Dogger Bank South Offshore Wind Farm

Appendix E3 to the Natural England Deadline 3 Submission
Natural England's comments and advice on Fish and Shellfish.

Planning Inspectorate Reference EN010125

19th March 2025

| Figure: 10-6e                                            | Drawing No: PB2340-MAR-OF-ZZ-DR-Z-0023 |                                                             |                     |

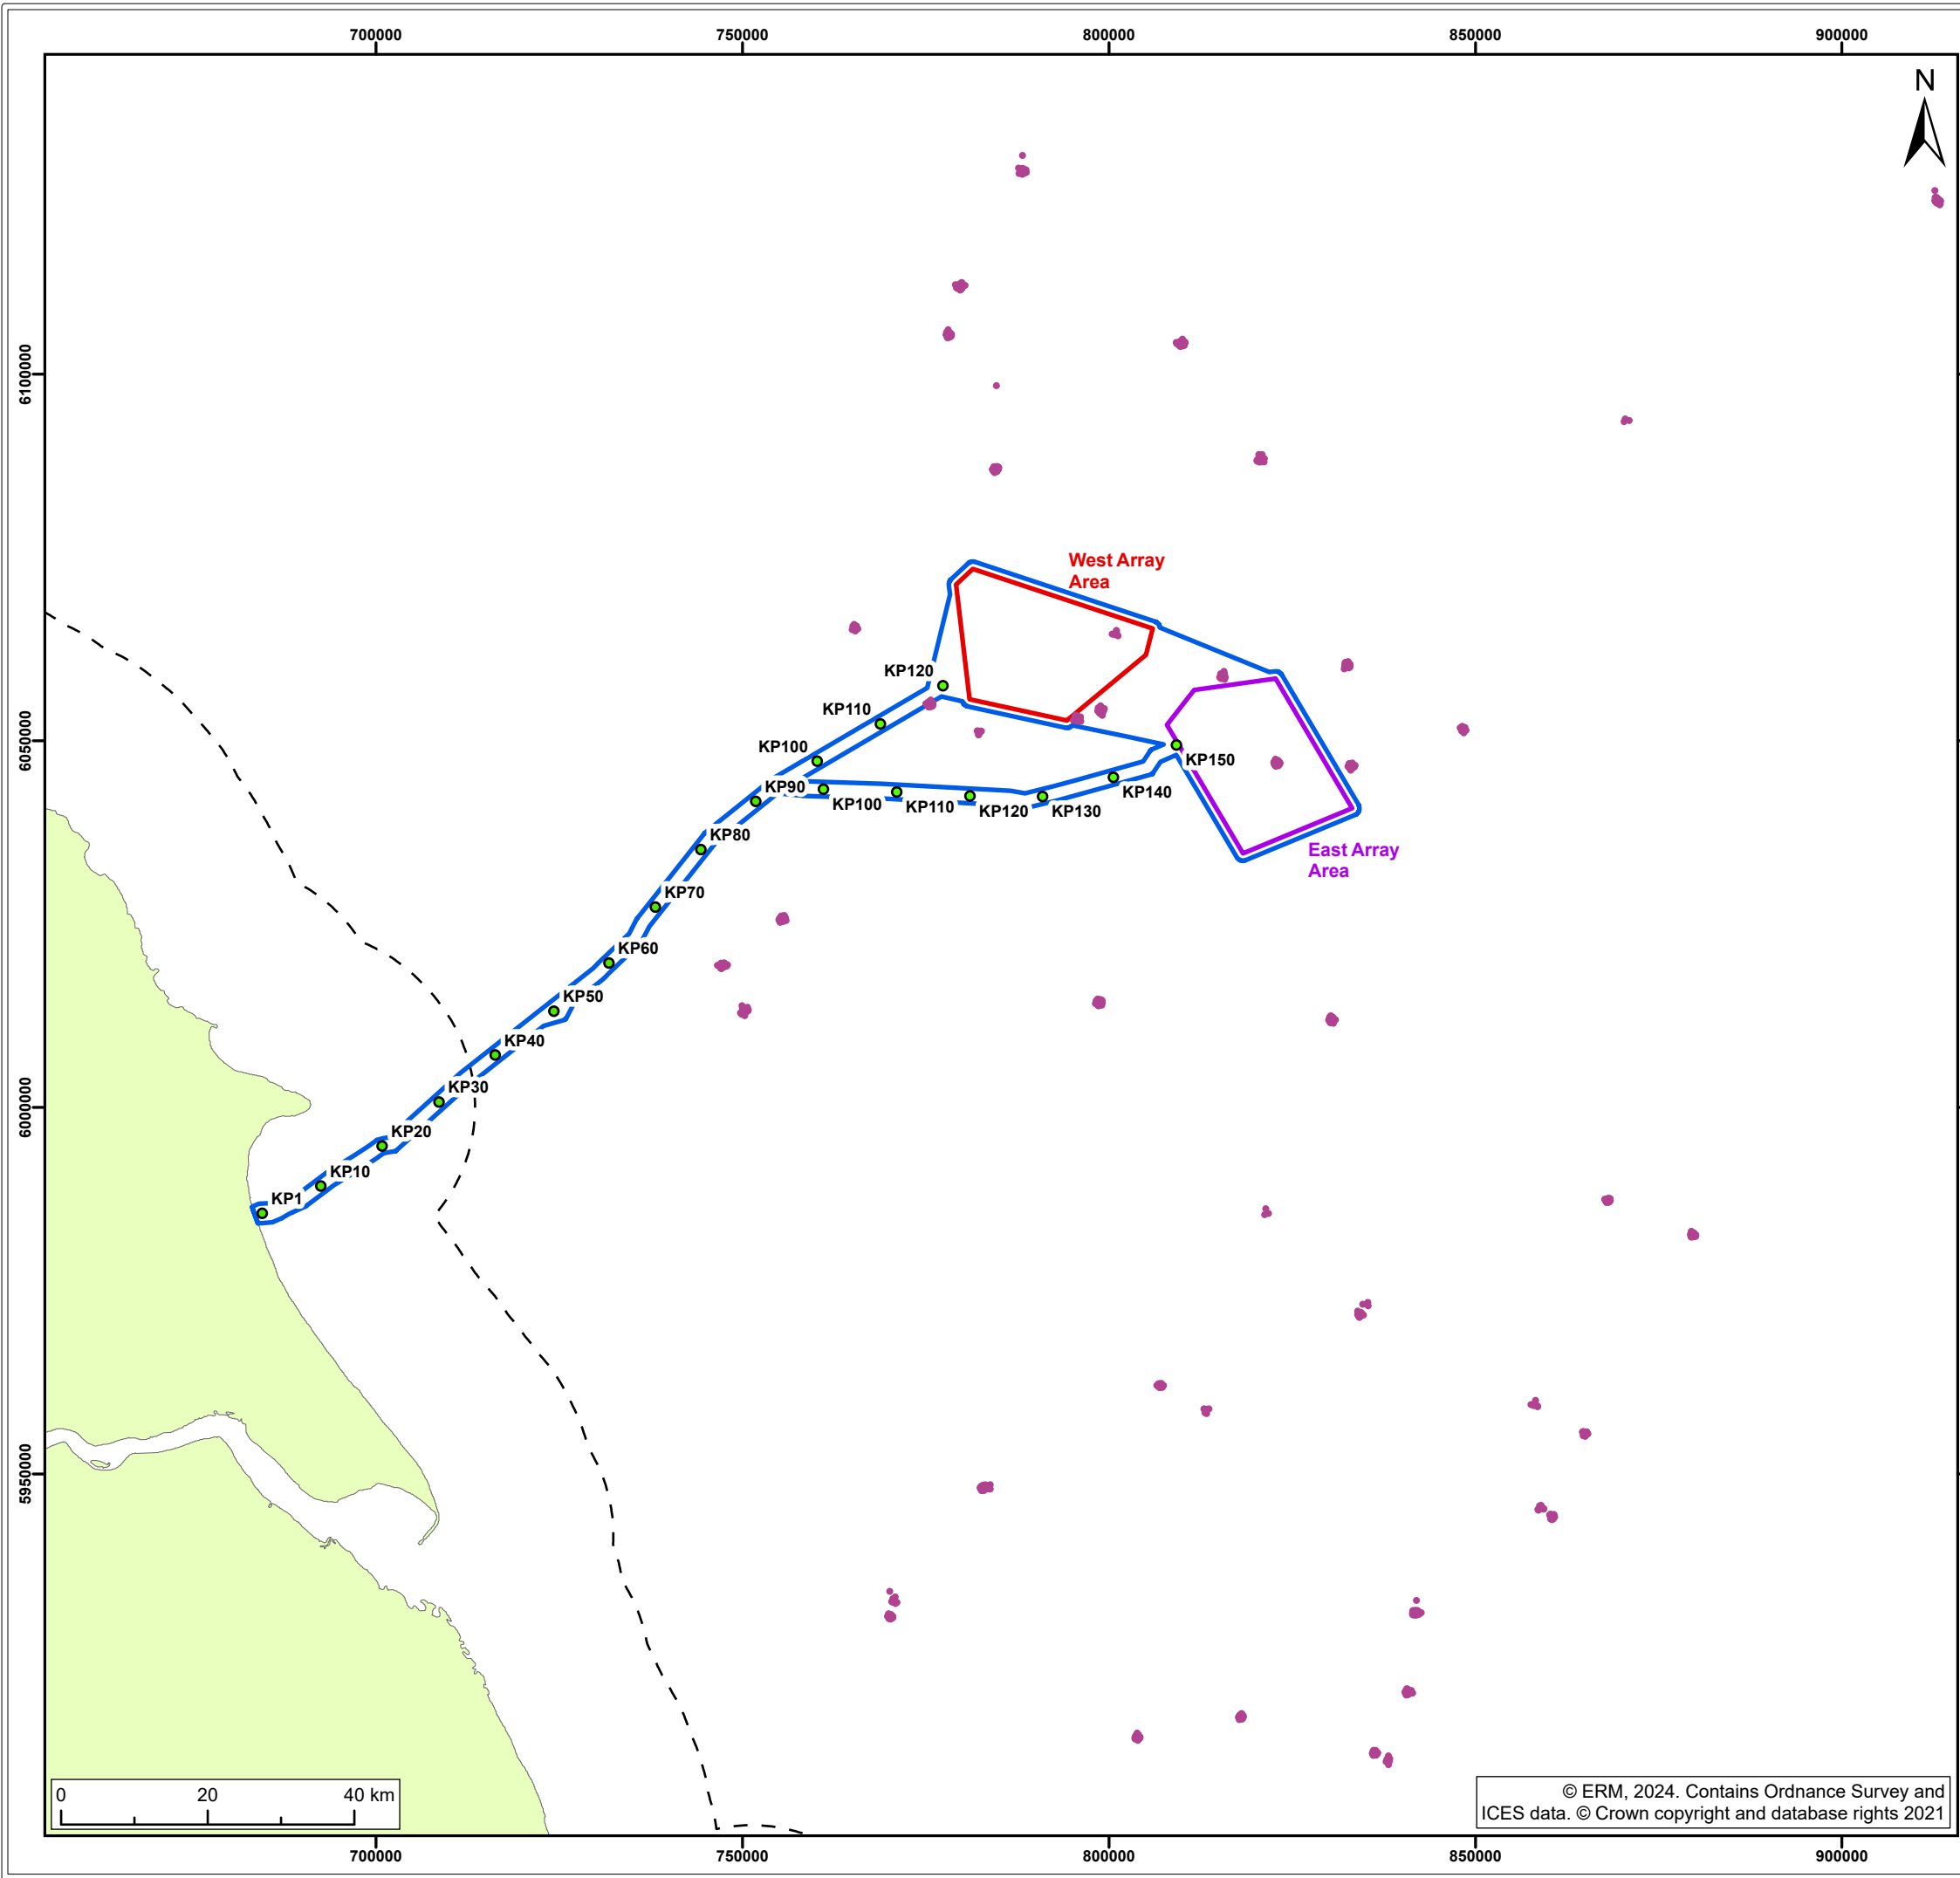
Natural England welcomes the review and update of the heat maps for Atlantic herring and sandeel provided in [AS-105]. We note only one year of Vessel Monitoring System (VMS) data (2020) has been incorporated, and request justification for this is provided as it will only provide a snapshot of fishing activity. We defer to Cefas regarding the detailed assessment of the methodology used by the Applicant.
